From: Easements&Development <Easements&Development@transgrid.com.au>
Sent: Friday, 10 May 2024 12:52 PM
To: Anthony McLandsborough
Cc: Easements&Development
Subject: 2024-149 Westgate Kemp Creek (SSD-23480429) [Official]
Attachments: 20-776-SKC67 - TRANSGRID PAD LOCATIONS[P1].pdf

Transgrid has no objections to the proposed development.

As per Anthony's advice below, I suspected this was the subject parcel of land. On the basis that the placement of the transmission tower pads have already been designed in consultation with Transgrid on the other adjacent land, I have no objection from a Property Portfolio perspective to their proposed development and land use in the easement.

TRANSGRID PAD
ARRANGEMENT

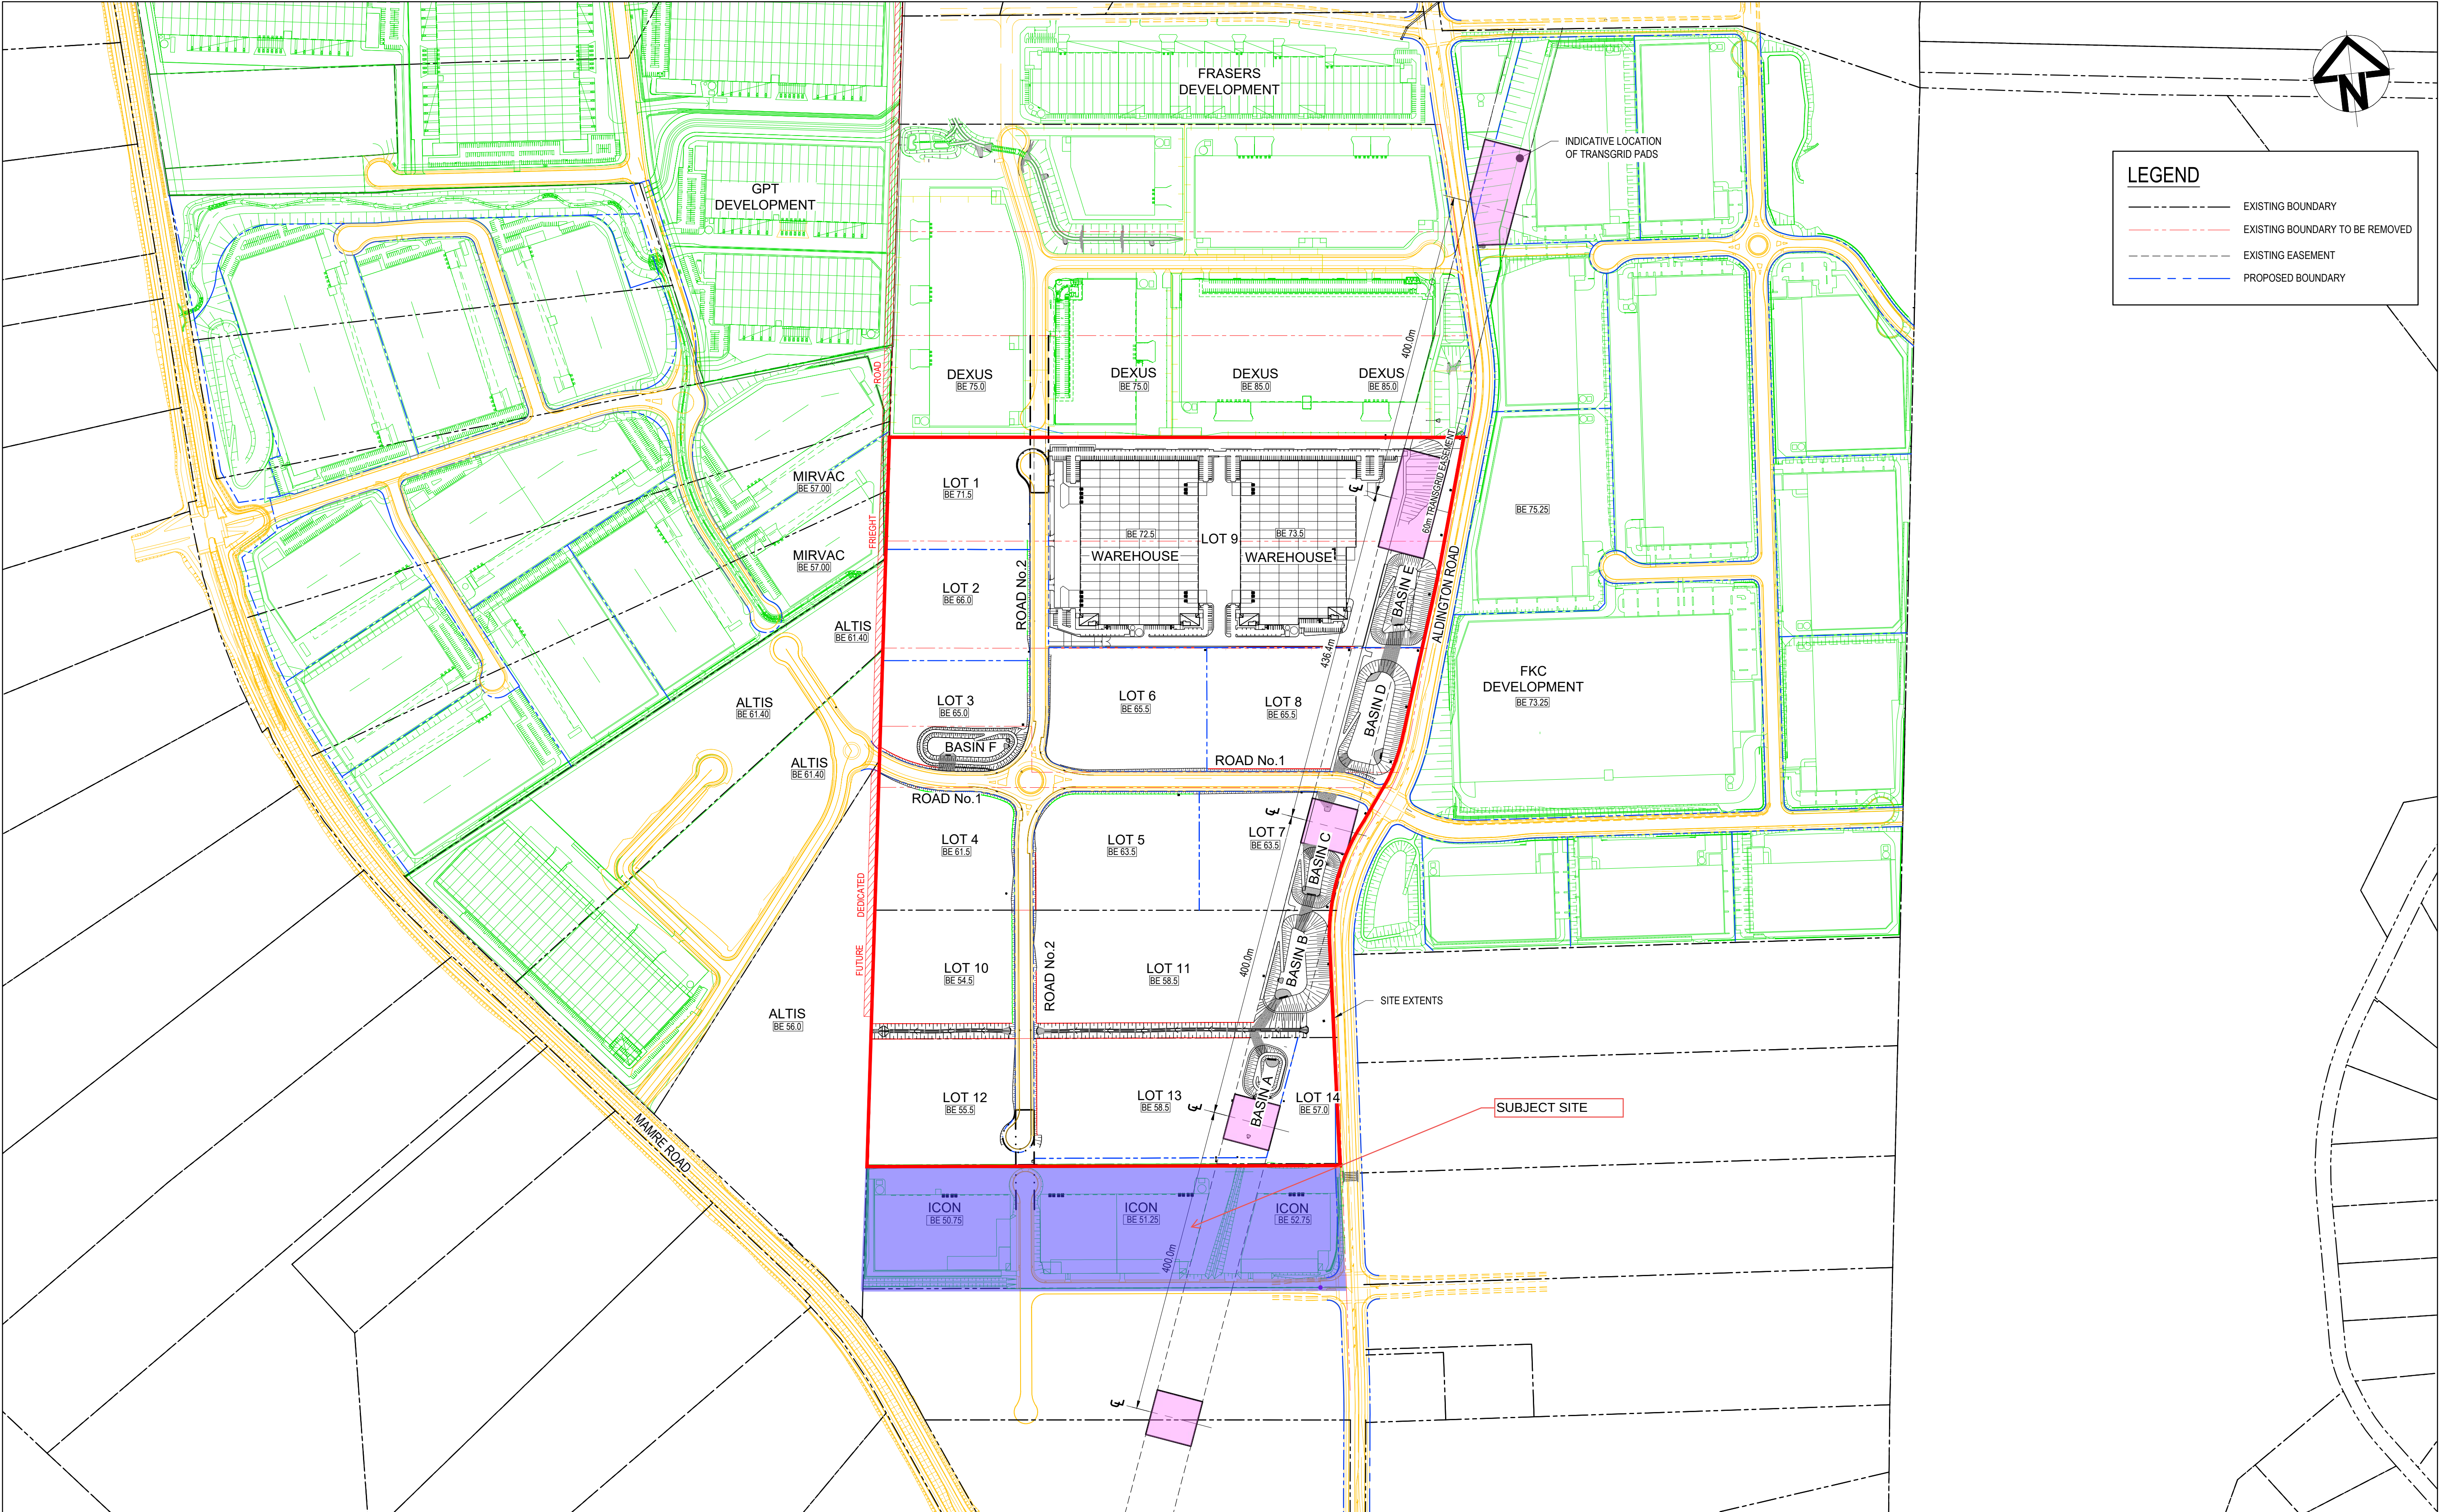
Referring to the plan provided by Anthony McLandsborough (at&I), it appears the location of the future transmission towers (and the Transgrid pads as they call it) have been defined along the easement. If we can confirm that the subject land does not need to accommodate one of our future transmission towers, then I have no objections to the proposed development.

It would be good if at&I could provide a **marked up plan** that identifies the subject landholding on the plan that shows the position of the proposed transmission tower pads at 400m spacings between towers.

You will see on the attached a proposed pad location is indicated directly north of the subject site and again some 400m south.

The location of the proposed pads are relevant to the extent of meeting Sydney Water trunk drainage scheme design. If the pad location directly north was to move south, this would impact the trunk drainage shown along with impacting the location of the pads north as we would not meet the 400m criteria.
